CITY OF ALBUQUERQUE

February 23, 2012

**Re: Plaza at San Mateo, Tract A Vidas Subdivision
2403 San Mateo, Grading and Drainage Plan
Engineer's Stamp Date 2/13/2012 (H17/D103)**

**GRADING PLAN**  
C201

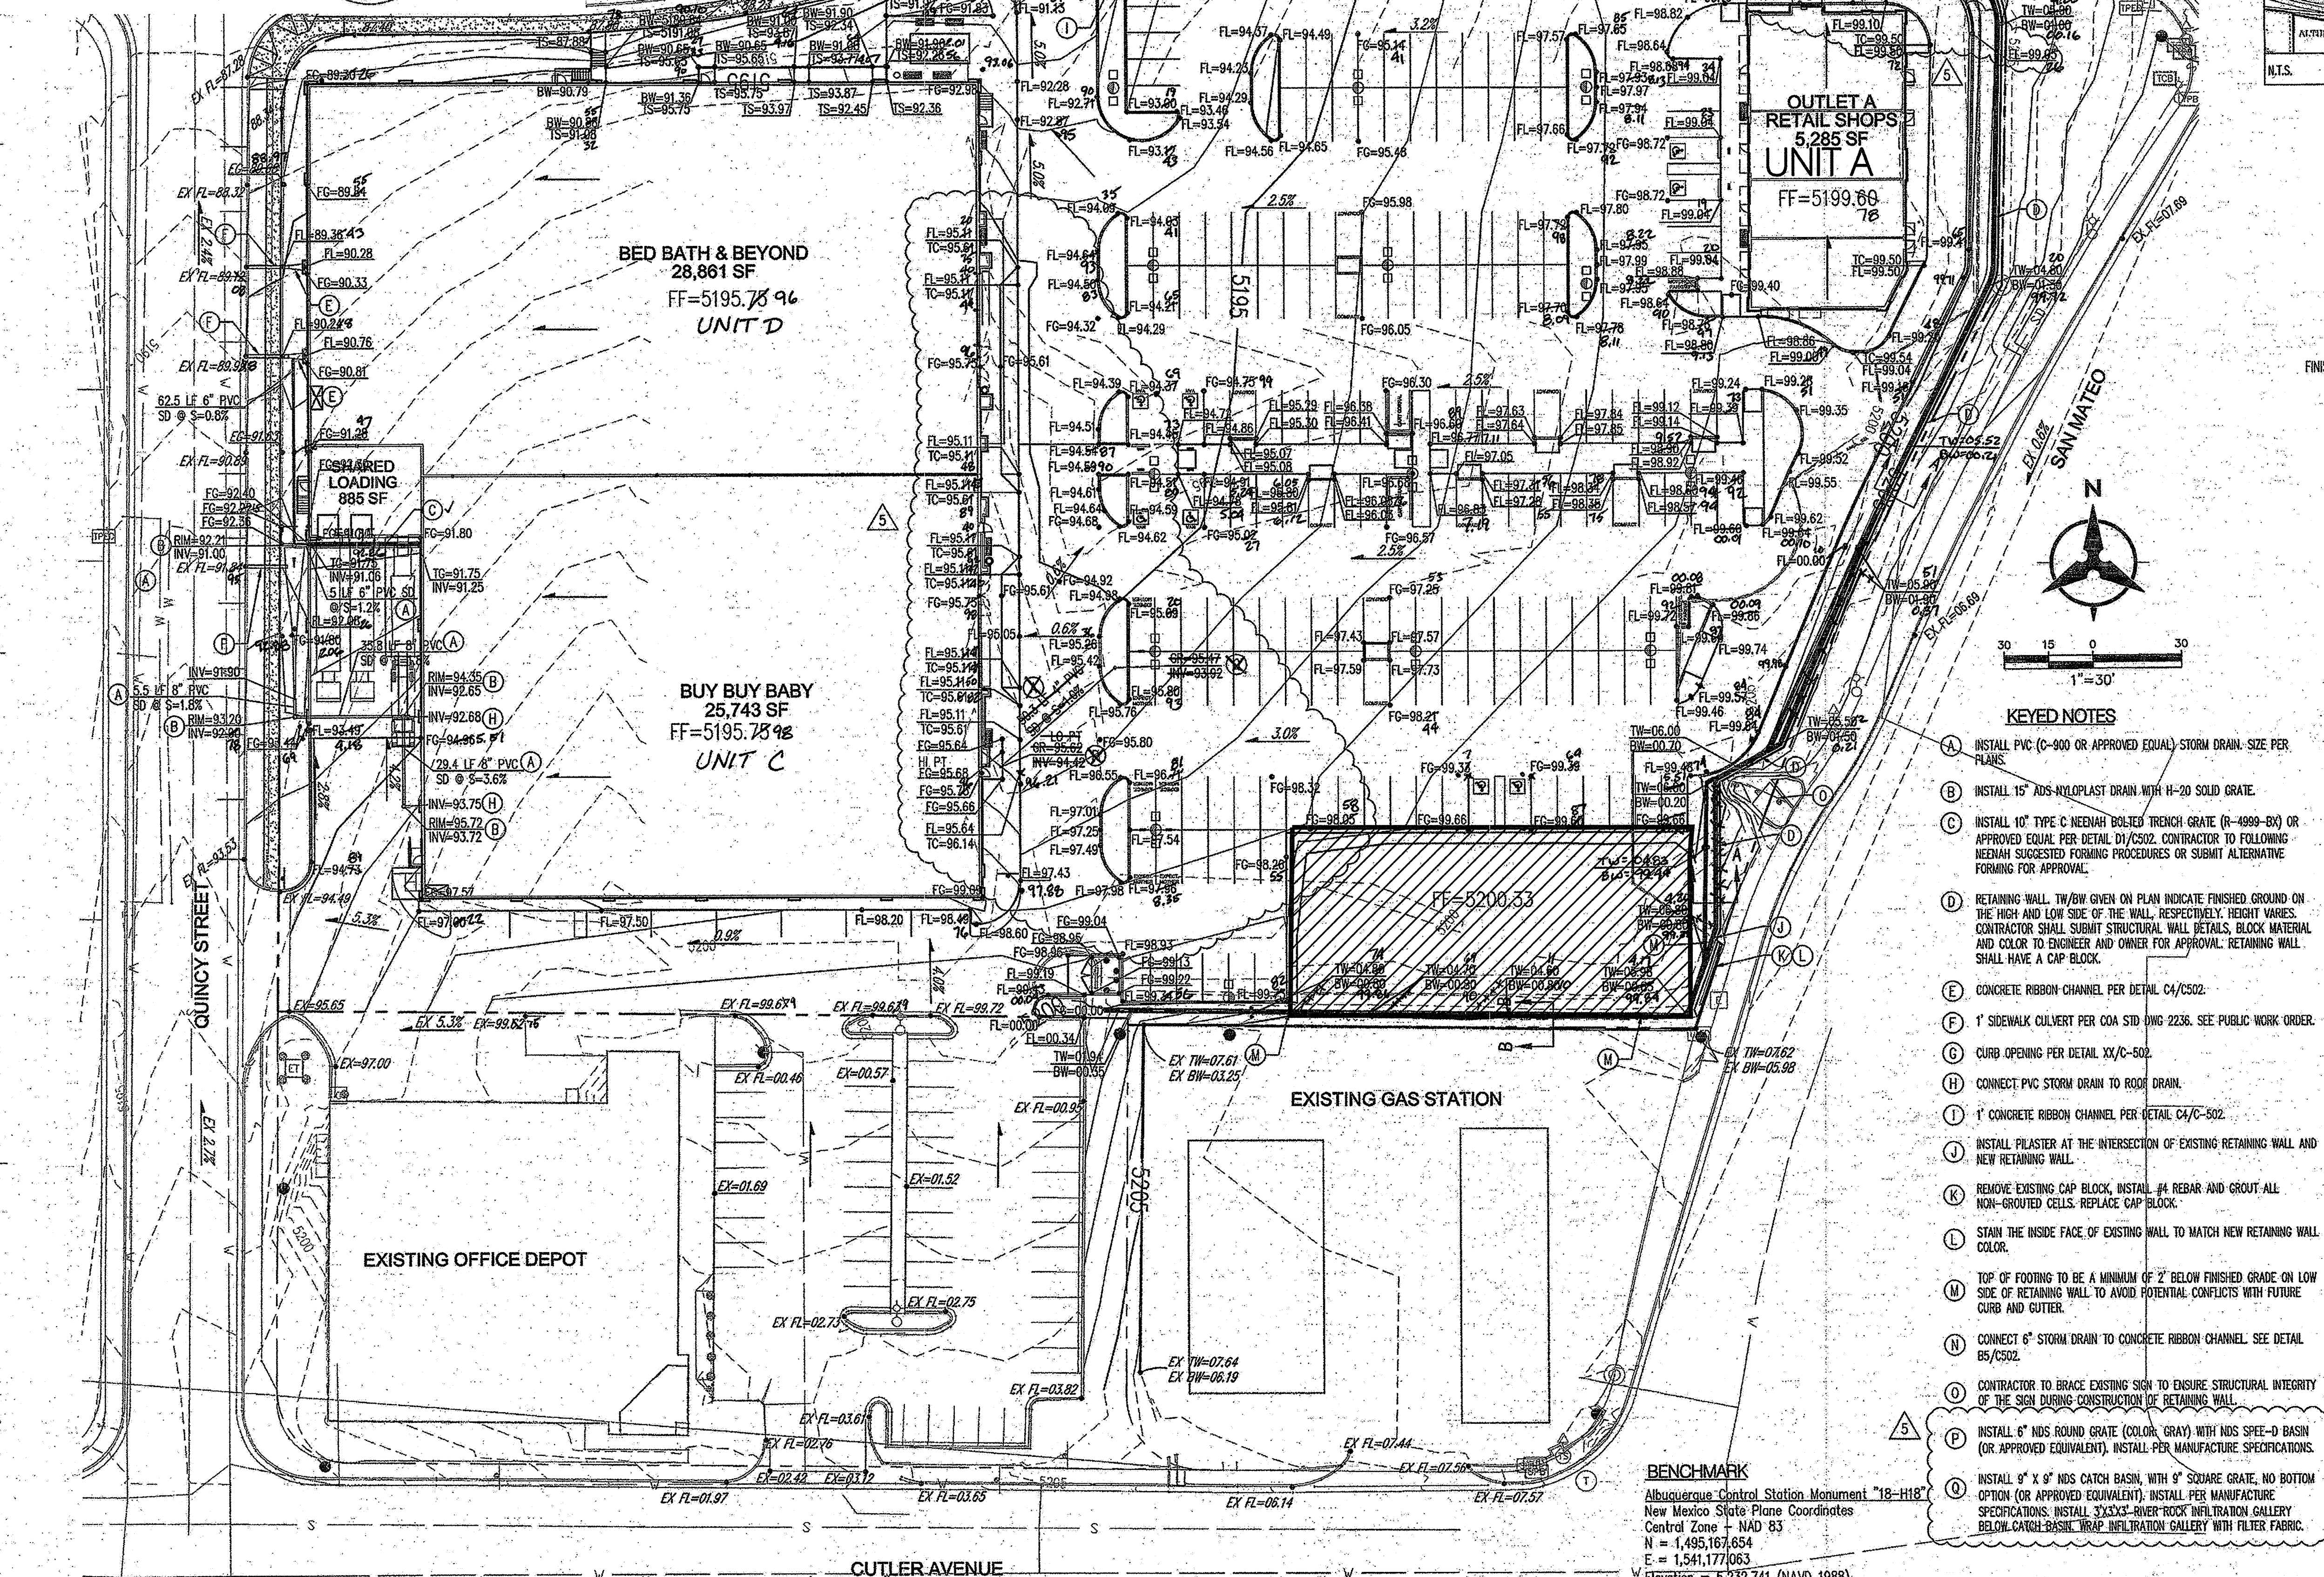
- Proposed retaining wall south side of Outlot B building may have to be extended west.
- Provide spot elevations on the south and east side of the Outlot B building.
- Appears that double retaining wall is shown for small area east of Outlet A building. Please provide TW/BW elevations.
- How will the loading area south side of the Bed Bath & Beyond drain? Provide more spot elevations for this area.
- An area northeasterly corner of the Bed Bath & Beyond building flows west. Where is the runoff draining to?
- Use sidewalk culverts and depressed landscaping areas to avoid draining the runoff over the sidewalks. Provide more spot elevations west and north side of Bed Bath & Beyond and Buy Buy Baby buildings.
- SO-19 notes will be required if sidewalk culverts are proposed.
